Your Ref: OWPC24514
Our Ref: FG/100/19/HH 31-08-2019
Please ask for:
Zac Denton

Single storey front extension
23 West Drive Ferring

Thank you for your internet representation made on 8th October 2019 which has been recorded as '**an objection**' with the comments as follow s:

Proposed Floor Plan

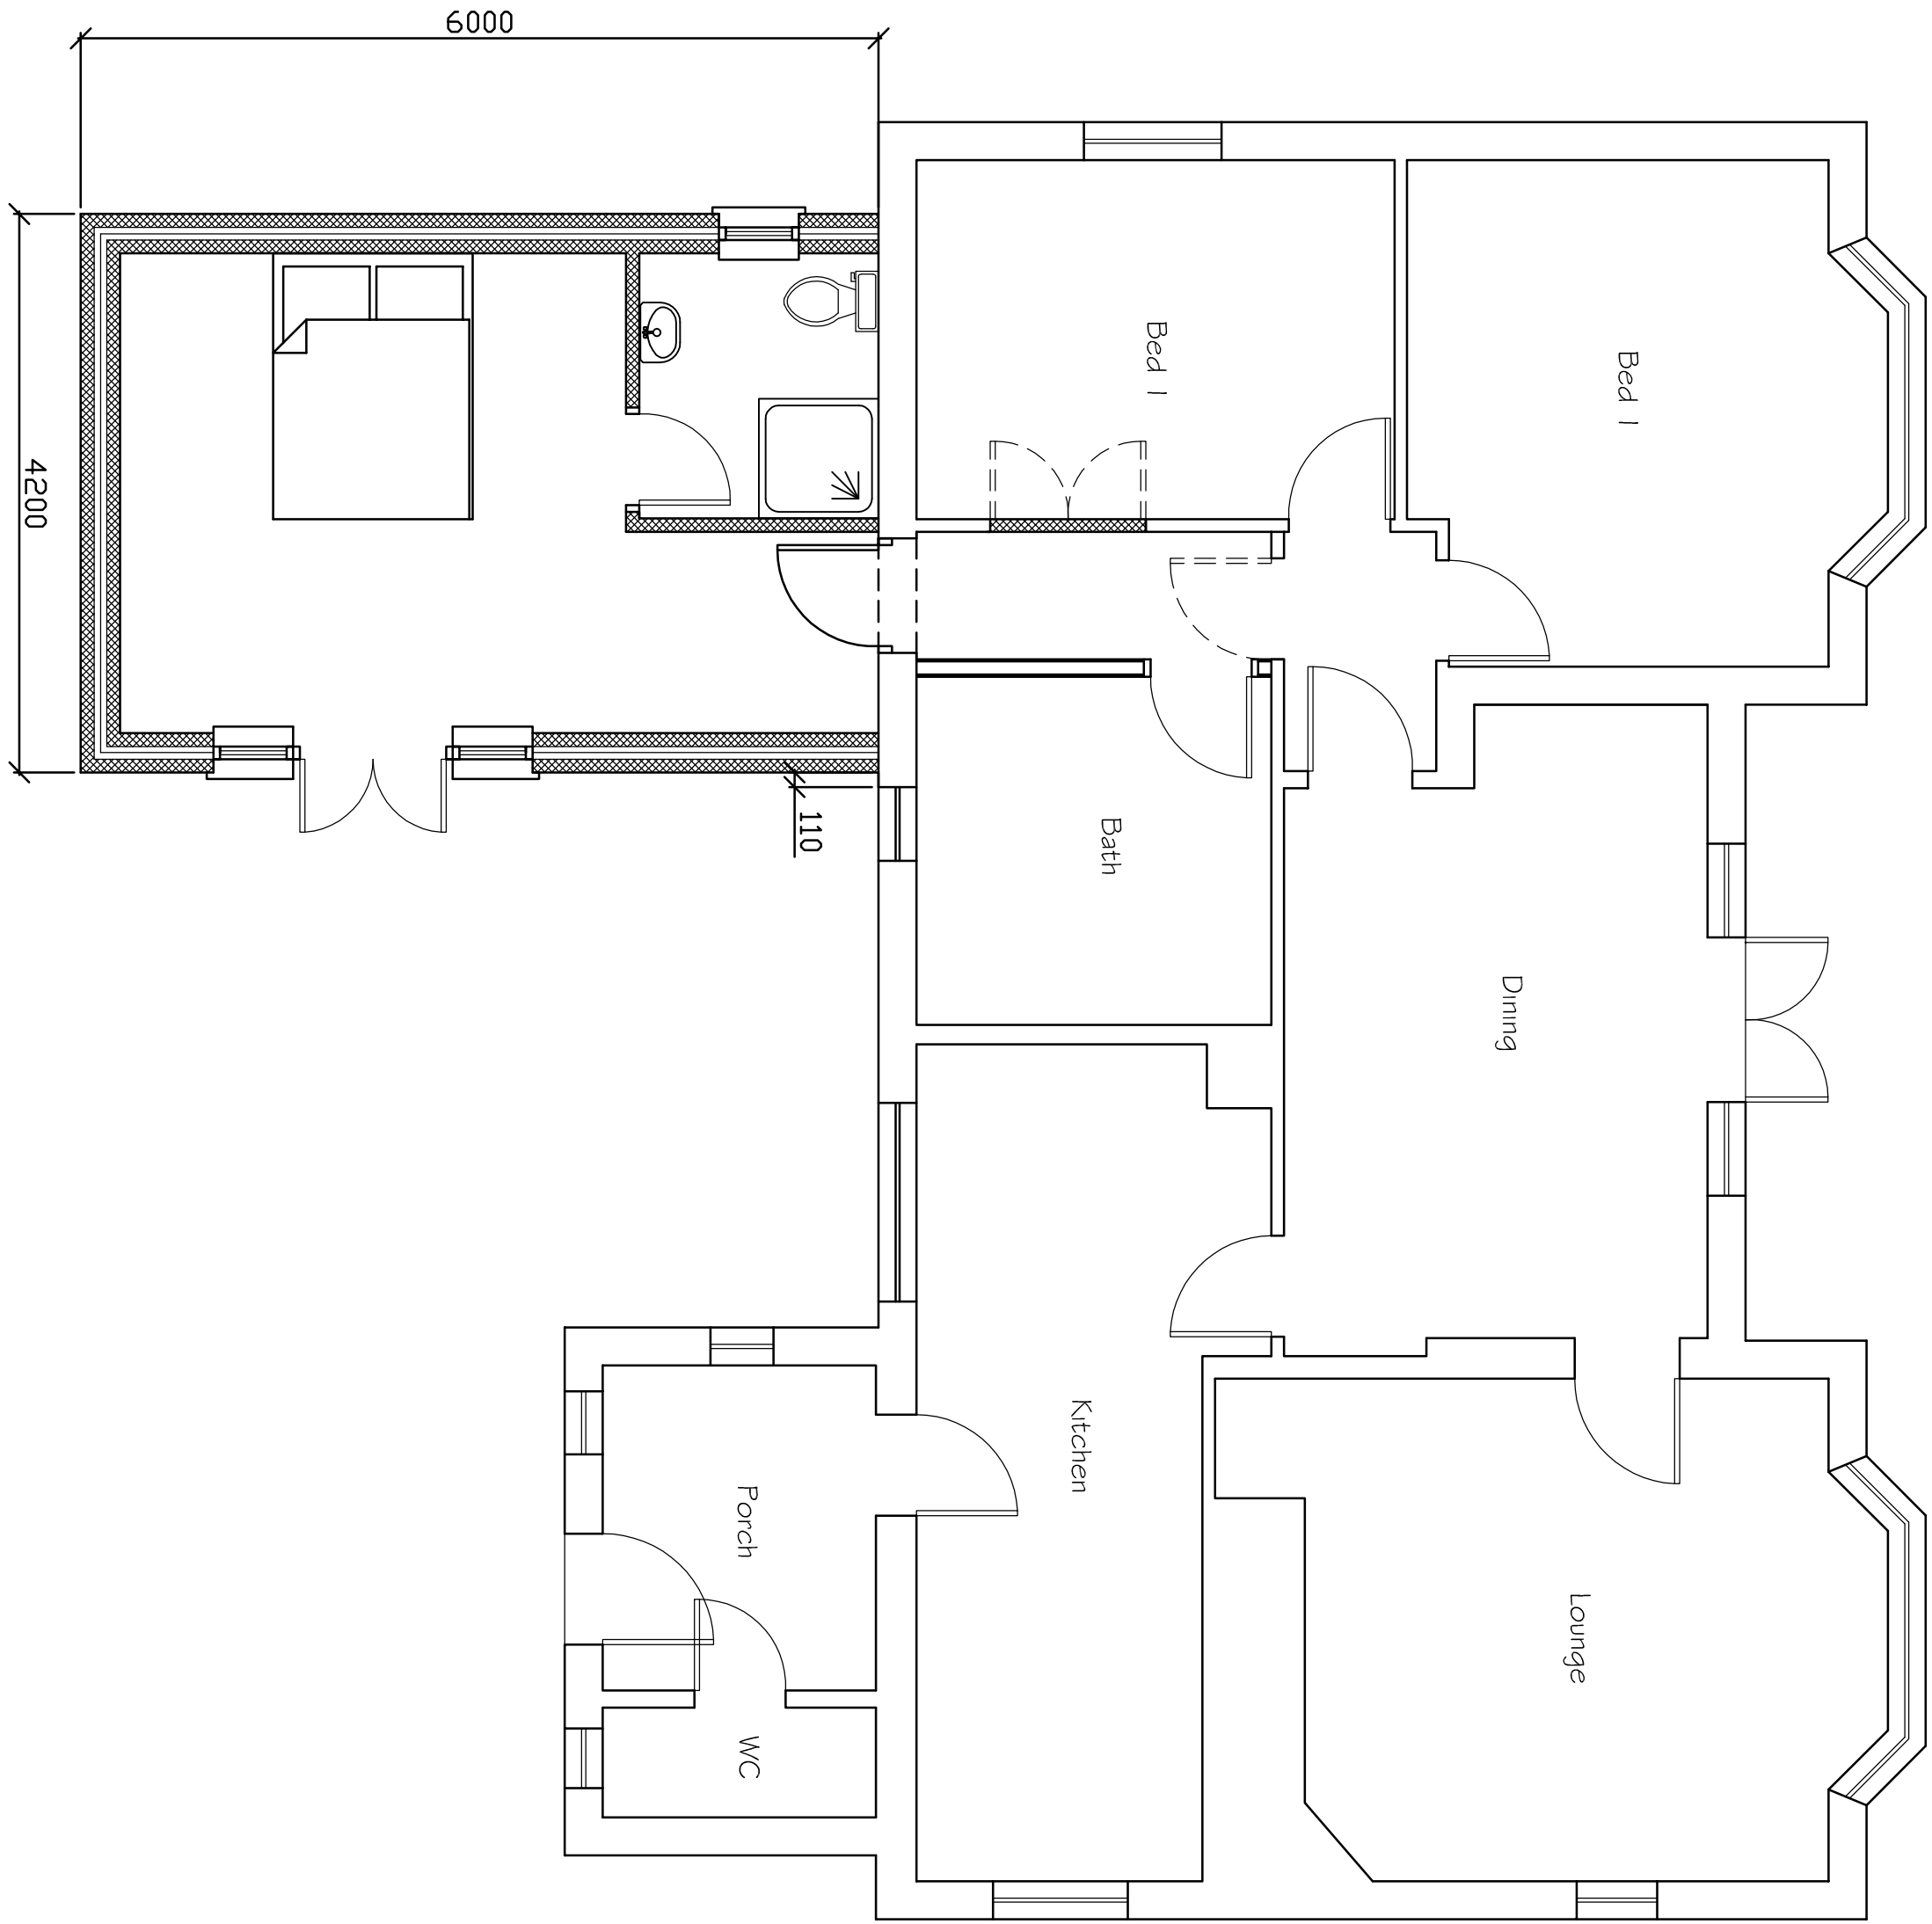
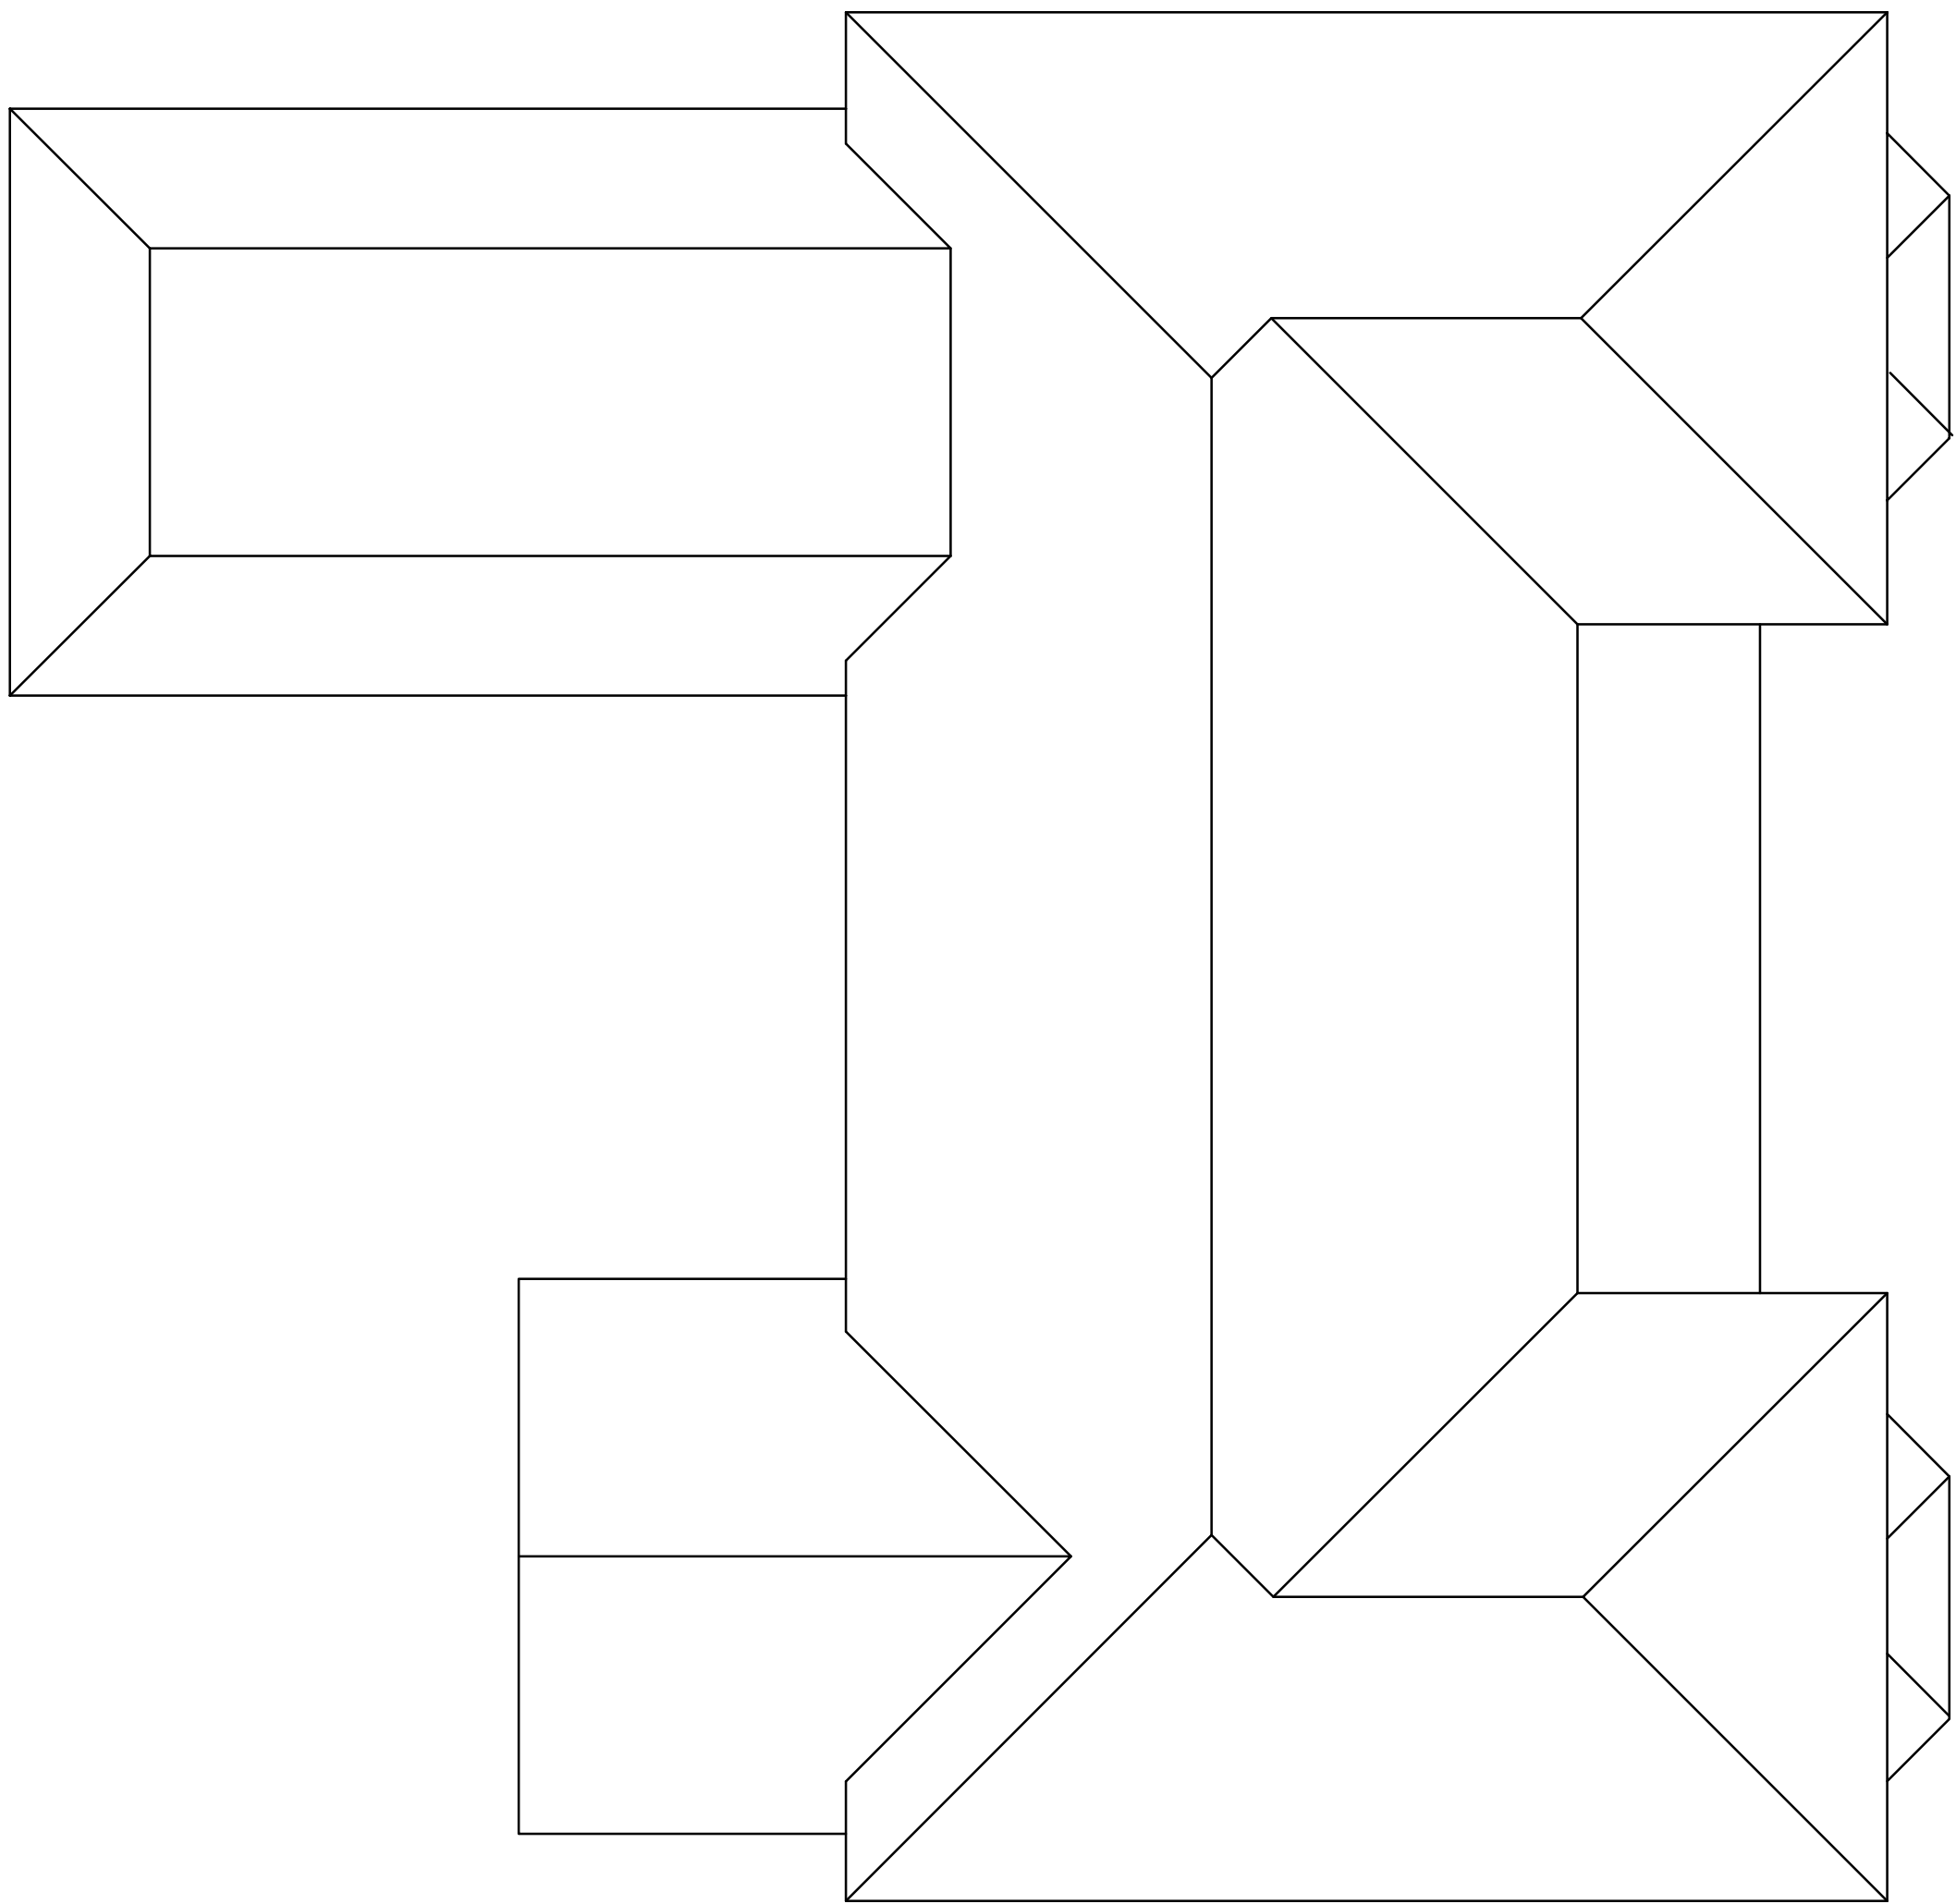
The proposed extension would impact greatly on the amount of natural daylight and sunlight entering adjoining and nearby properties located within The Poplars. This building would overshadow 14 & 15 The Poplars and obscure essential light. This proposed extension runs parallel to the back of 14 The Poplars, with the living room located just 2180mm from the boundary fence. This extension would be built approximately 1400mm from the boundary, and just 3580mm from the patio doors. I feel this is unacceptable for my Mother, who owns 14 The Poplars, and her neighbour at 15 The Poplars.

The proposed extension is to build a bedroom with ensuite facilities. The opening window to the ensuite is positioned directly opposite the patio doors of 14 The Poplars, the patio doors lead into the main living area. Below this window is a toilet which is 1400mm from the boundary wall and close to an area my Mother likes to sit and enjoy her garden. My objection is to the loss of privacy, overlooking and the noise from daily ablutions and the use of the toilet, which would most definitely be heard from 14 The Poplars, and very likely to be heard from 15 The Poplars.

I object to the design, layout, and density of the proposed building in respect of its size, width, height, massing and also the overpowering and overbearing affect predominantly on 14 The Poplars. The impact of one continuous wall along the back of the very small garden of 14 The Poplars would diminish greatly my Mother's rights to enjoy her garden and property. The scale and massing of this proposed extension is out of proportion to the large amount of external land available at 23 West Drive.

This extension would adversely affect the visual amenity that is enjoyed at my Mother's property. The overbearing nature of this proposed extension would overshadow my Mother's small strip of garden. It would create a continuous wall that would obliterate light and create a feeling of being hemmed in. The close proximity of the bathroom is unacceptable when the 'use of the facilities' would be audible from 14 The Poplars. The design of this proposed building is unusually to the front of the house, which is somewhat irregular when considering the vast area of land available. I believe an alternative site at the back of the property would be more in-keeping with this property.
